From: Lloyd Gray [REDACTED]
Sent: 18 January 2018 15:44
To: Paul Cann
Cc: Mark Akmenkalns; Malcolm Wilkes; Jonny Ribbans ; Simon Davis
Subject: RE: D1304: 27 North Bersted Street BE/106/17/DOC - Planning Conditions Comments

From: Paul Cann <[REDACTED]>
Sent: 19 December 2017 14:38
To: Lloyd Gray <[REDACTED]>
Cc: Mark Akmenkalns <[REDACTED]> Malcolm Wilkes <[REDACTED]>
Jonny Ribbans <[REDACTED]>
Subject: RE: D1304: 27 North Bersted Street BE/106/17/DOC - Planning Conditions Comments

TYPICAL HYDROBRAKE MANHOLE DETAIL
Hydrobrake chambers and Hydrobrake apparatus to be in accordance with Hydro International Stormwater's specifications
(Scale 1:20)

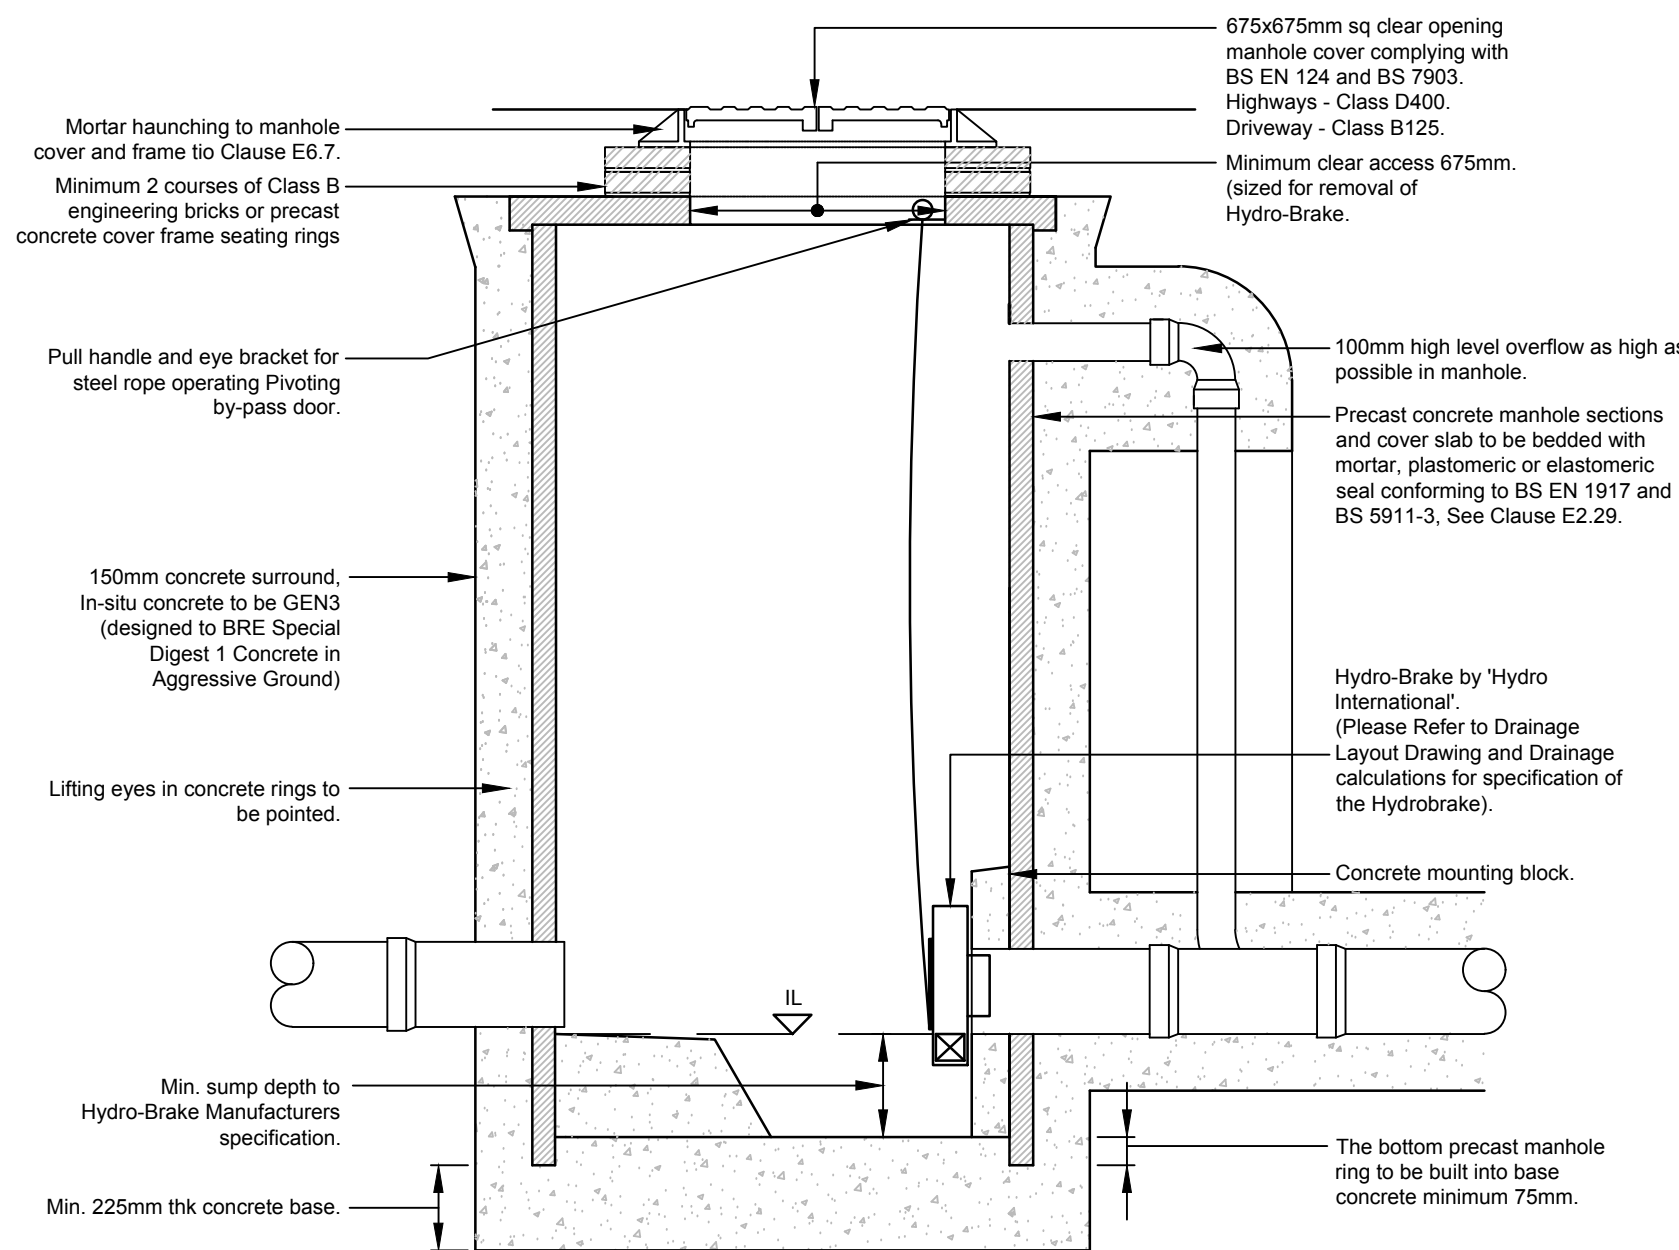
My concern is the proposal for individual residents to be responsible for the access road and the associated drainage elements (ie. hydrobrake, permeable surface, perforated pipework, channel drain, sump manholes, etc). Whilst there may be a legal agreement proposed, I would like to see a draft. How will the agreement ensure a co-ordinated approach to maintenance and by inexperienced people? Will they be forced to employ a suitably qualified contractor?

Our Client is now intending to go for the Management Company approach and the document updated to reflect this.
